CITY OF ALBUQUERQUE

**Re: Storage Building
4100 Yale NE
30-Day Temporary Certificate of Occupancy
Transportation Development Final Inspection**
Engineer's/Architect's Stamp dated 4-19-18 (G16D095F)
Certification dated 9-8-21

SITE PLAN

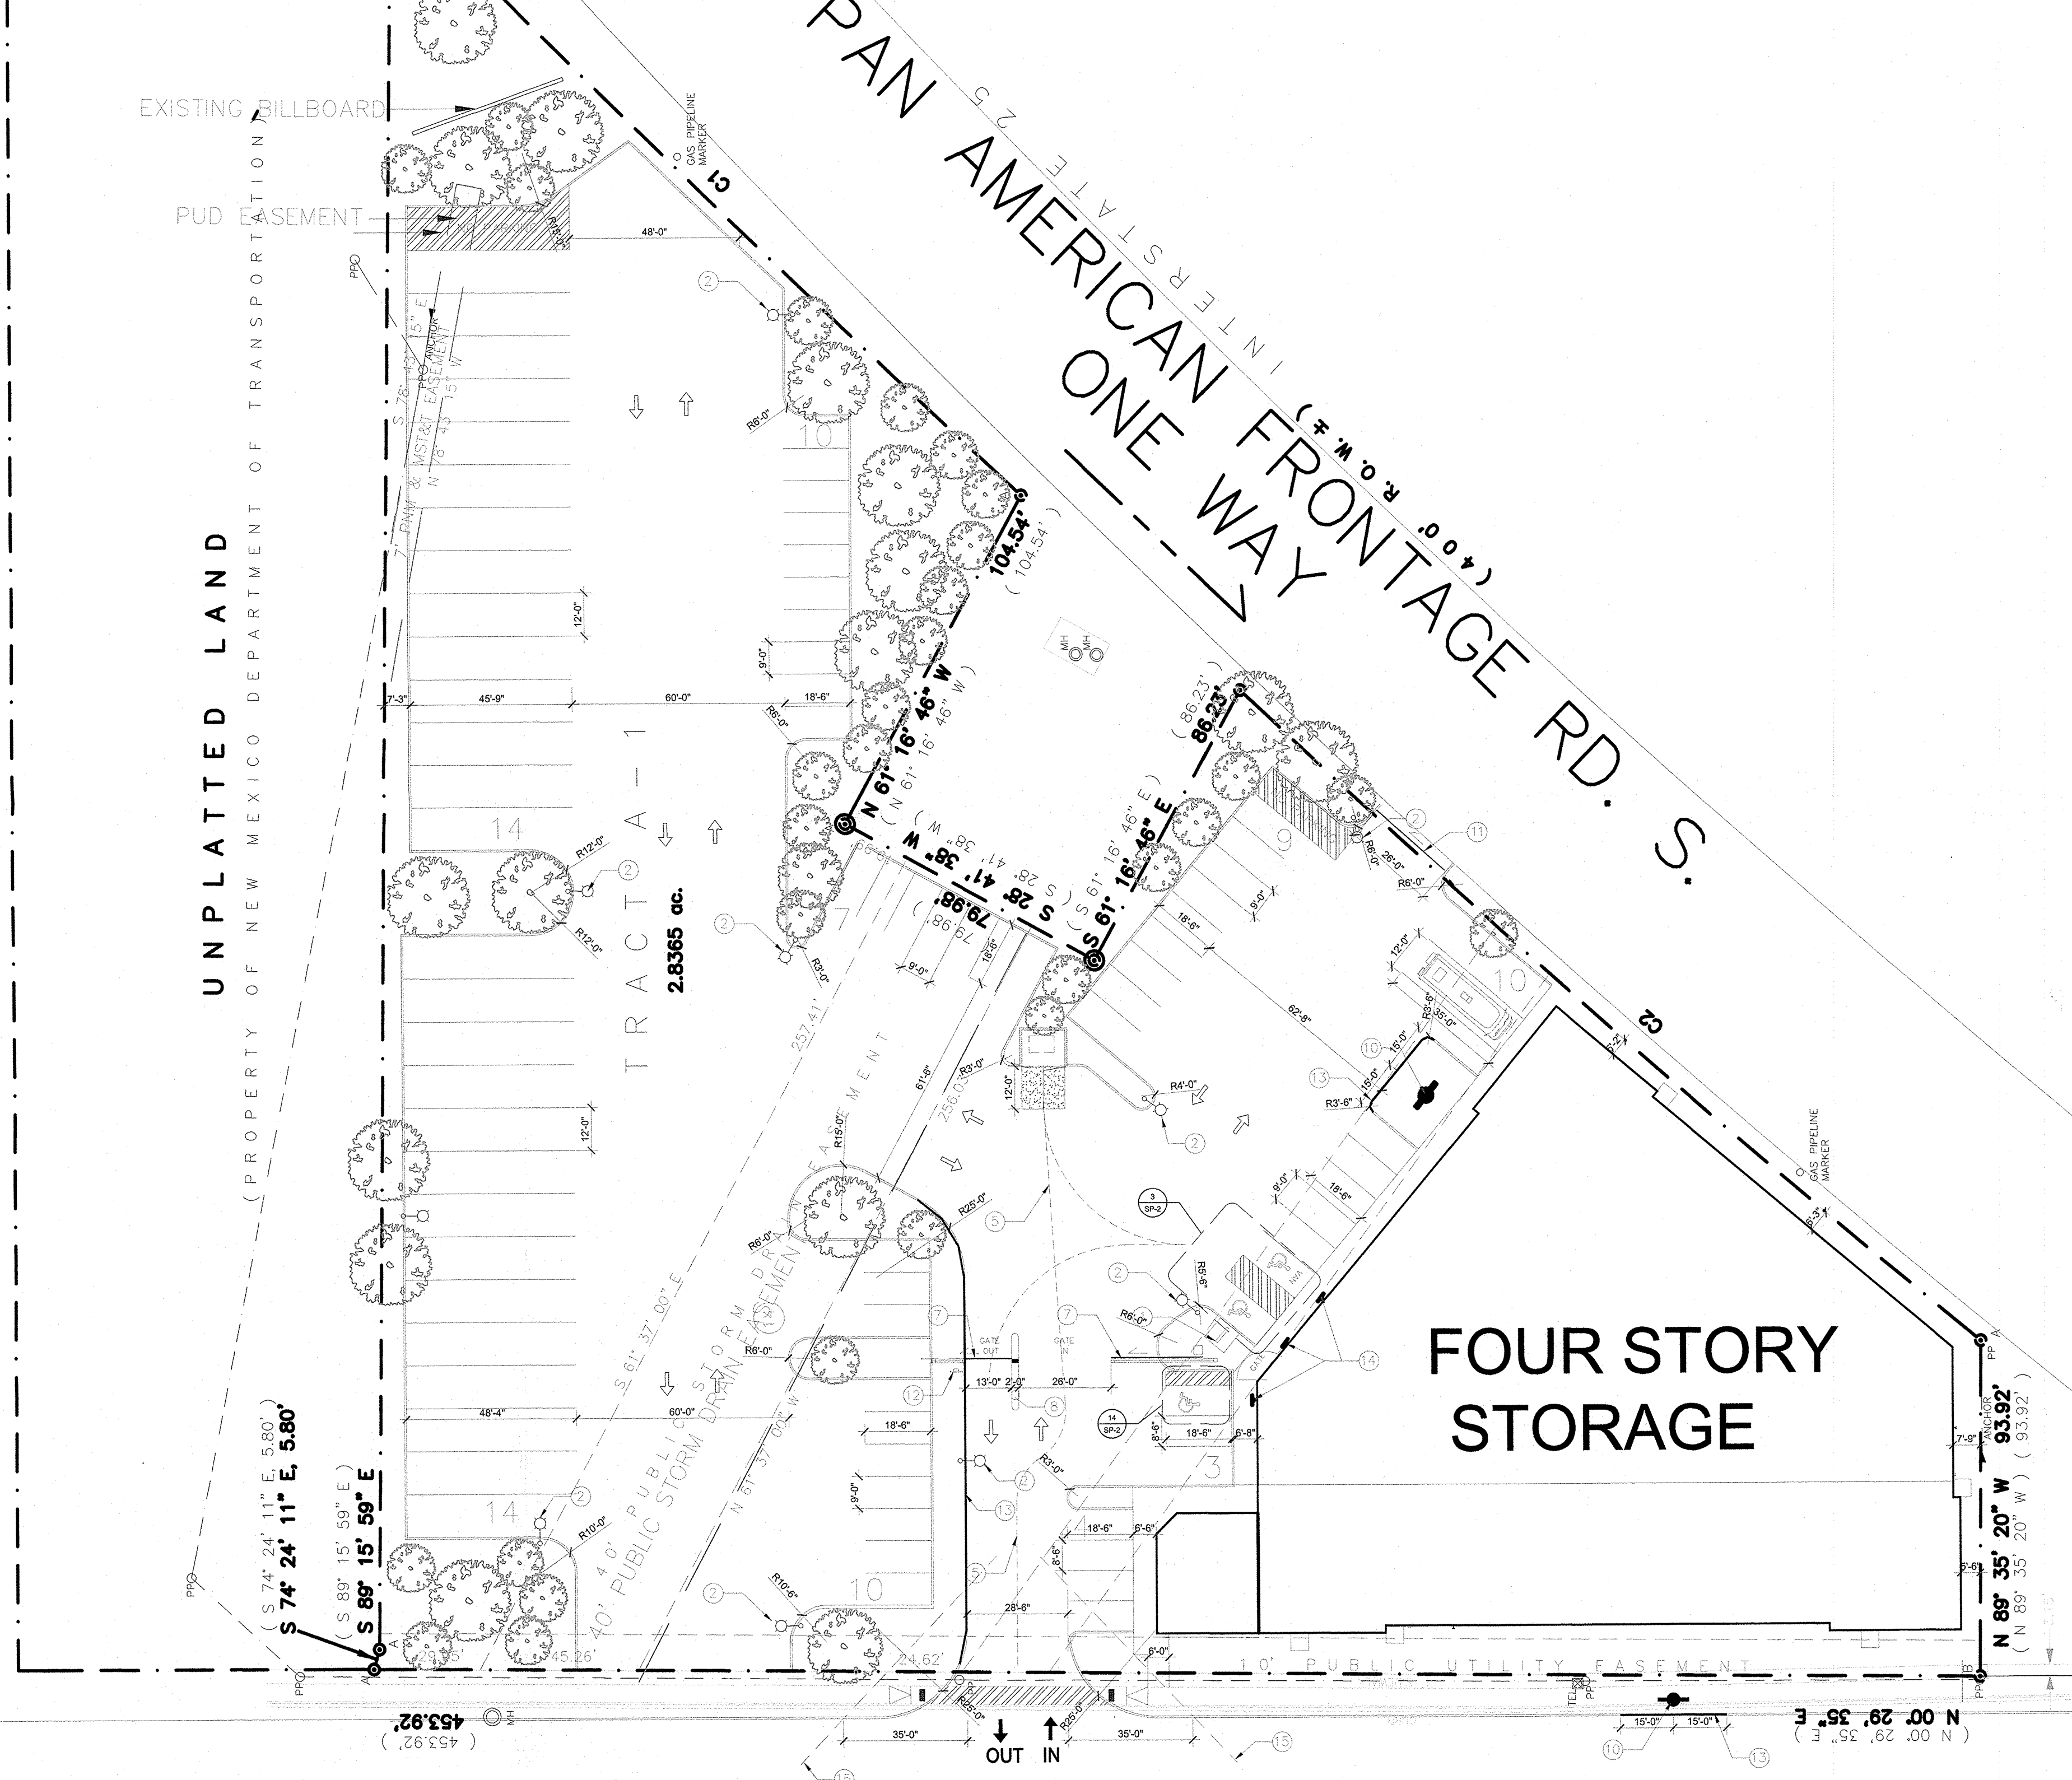
- Please add bike rack & Do Not Enter sign per approved TCL
- Add directional floor markings & Pavement Markings Per TCL
- Redline TCL to reflect site changes.
